3/2018/1169

Application for a non-material amendment following a grant of planning permission.

SINGLE STOREY KITCHEN EXTENSION TO REAR; REPLACEMENT OPEN ENTRANCE PORCH TO FRONT; DETACHED GARPORT; ALTERATIONS TO ENTRANCE / DRIVE AND ASSOCIATED EXTERNAL WORKS.

- ① FOR DESIGN FOR THE PROPOSED DETACHED GARAGE / CARPORT
- ② FOR DESIGN OF THE WINDOW ARRANGEMENT IN THE PROPOSED KITCHEN EXTENSION
- ③ FOR CHANGE FROM A RAMP TO STEPS UP INTO THE SOUTH GARDEN (AT SOUTH EAST CORNER OF THE HOUSE)

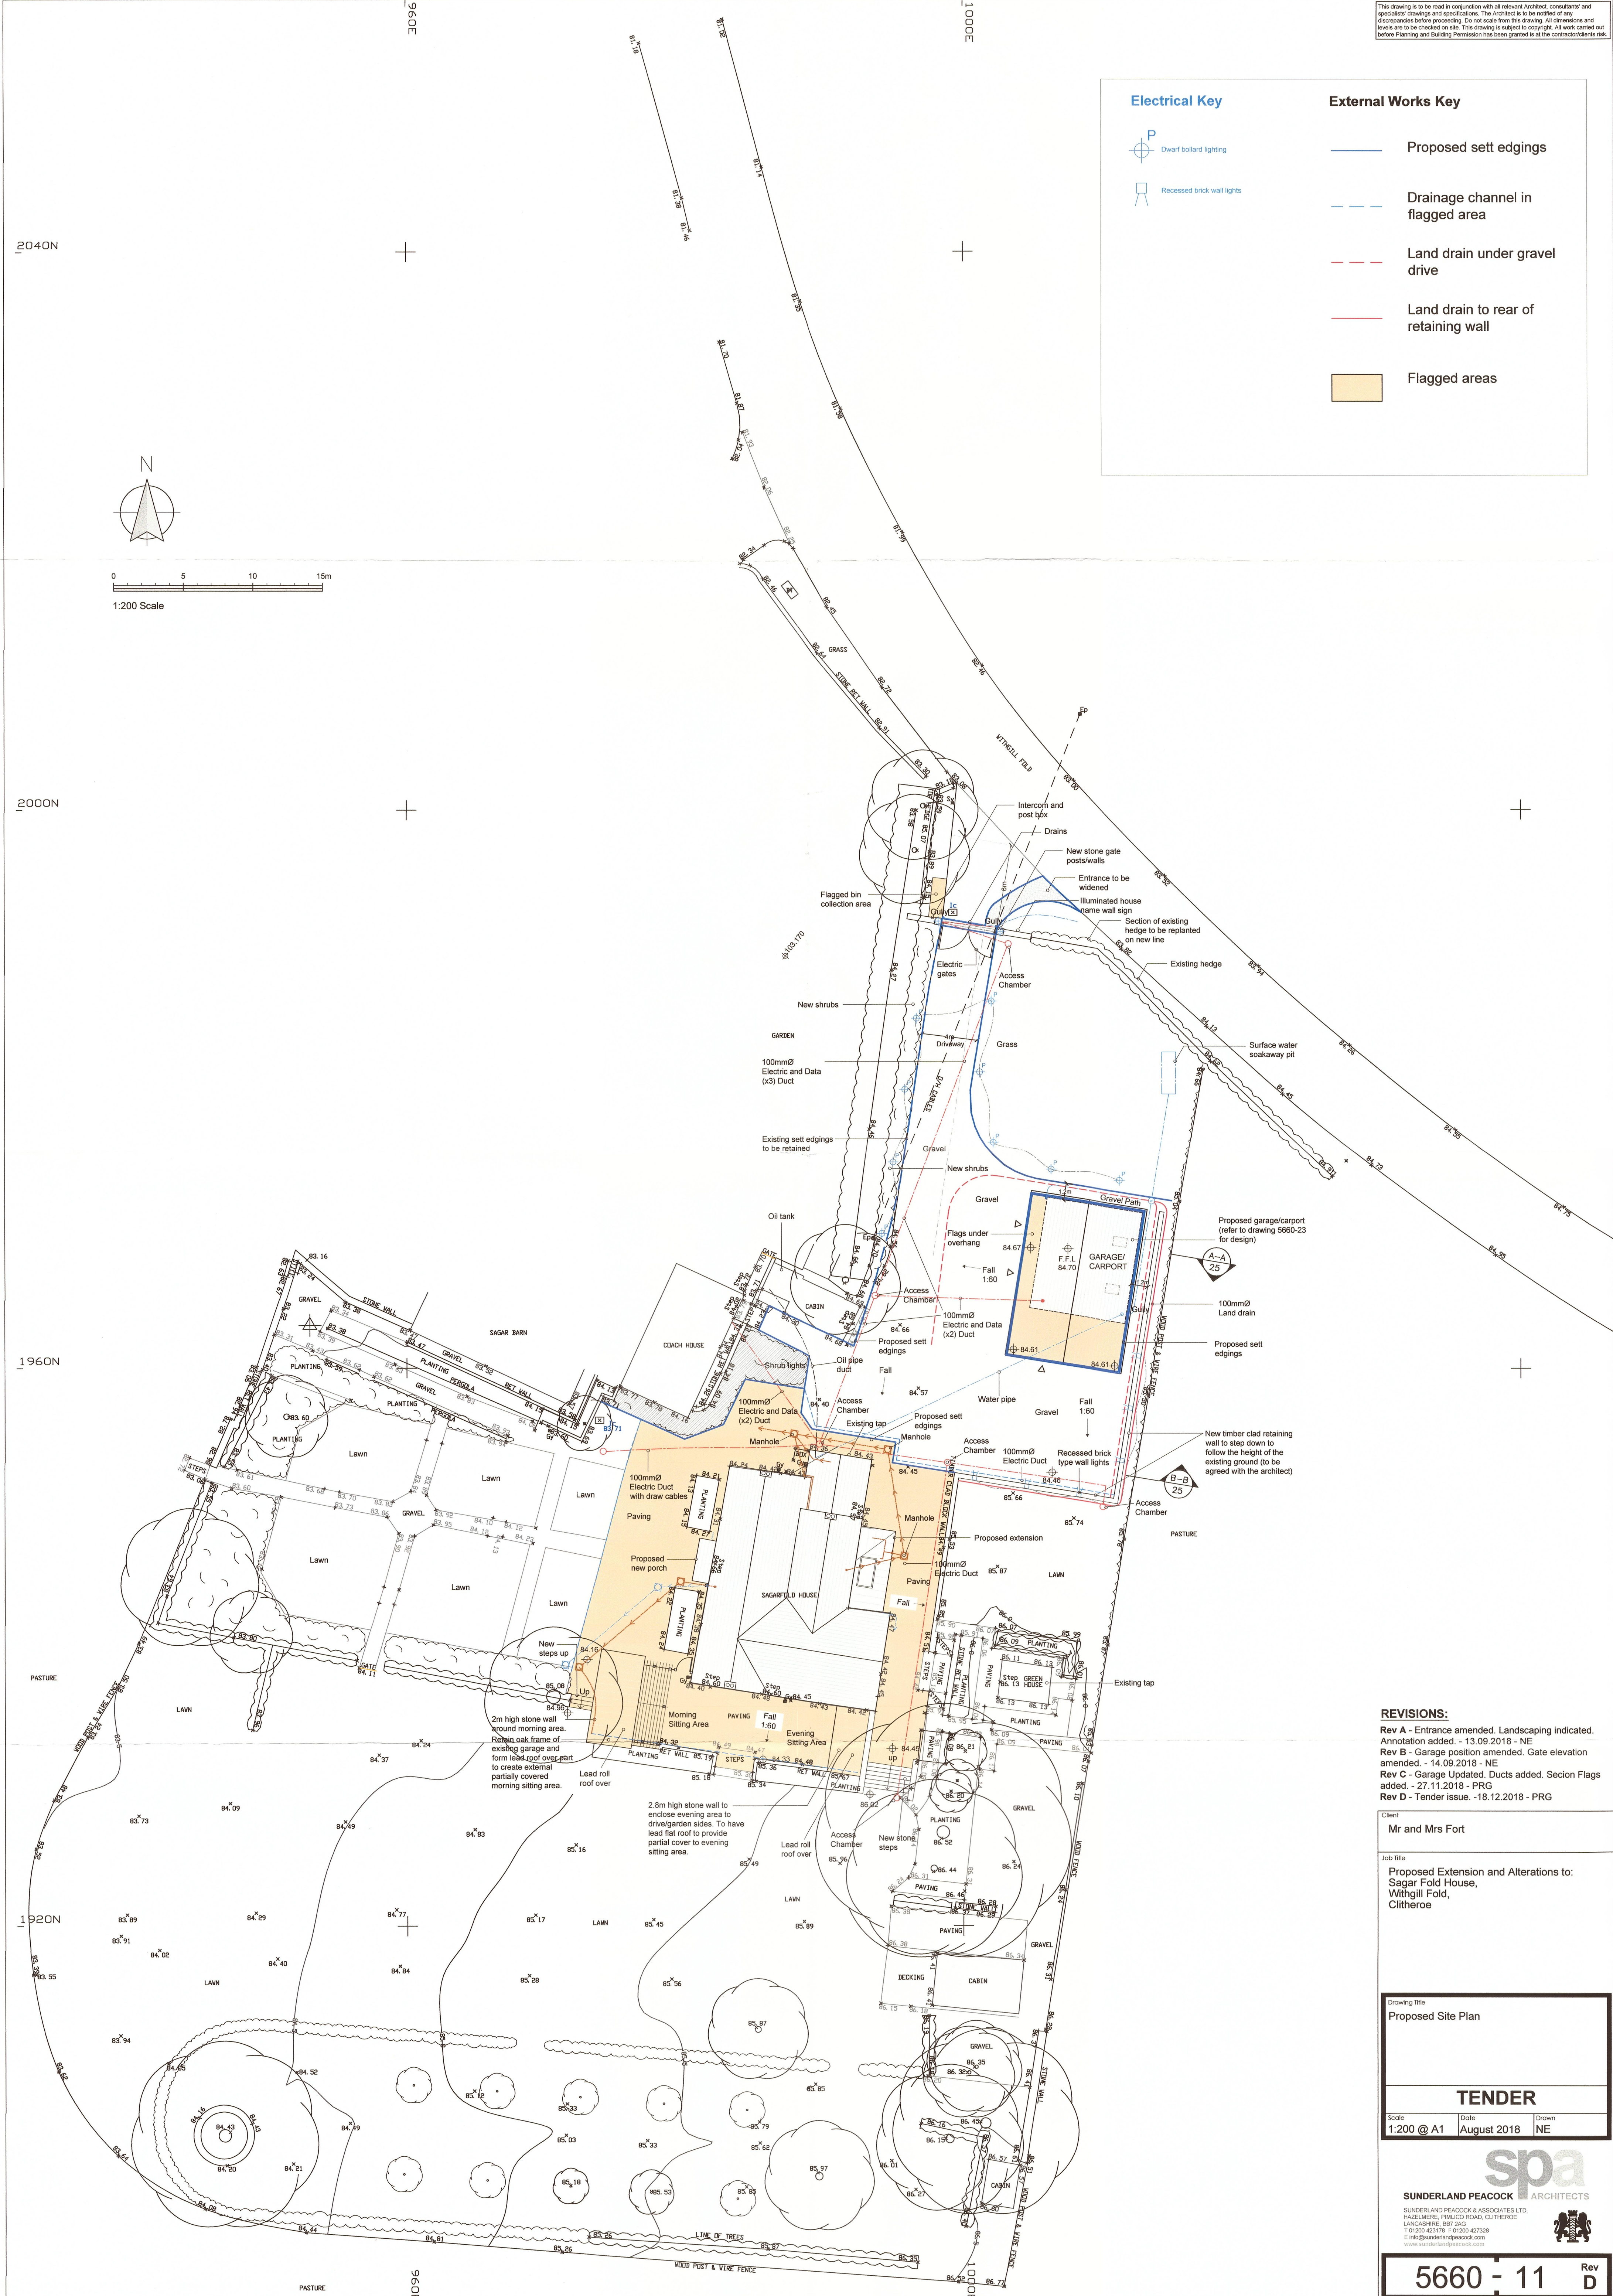
- ① TO FACILITATE A STONE BUILT GARAGE WITH OPEN OAK FRAMED CARPORT CLOSE TO HOUSE
- ② TO SUIT DETAILED DESIGN AND KITCHEN LAYOUT REQUIREMENTS
- ③ TO SUIT EXTERNAL LANDSCAPE DETAILED DESIGN REQUIREMENTS

5660-07 REV A (PROPOSED GARAGE), 5660-11 REV D (PROP. SITE PLAN) & 5660-14 REV D (PROP. PLANS & ELEV)
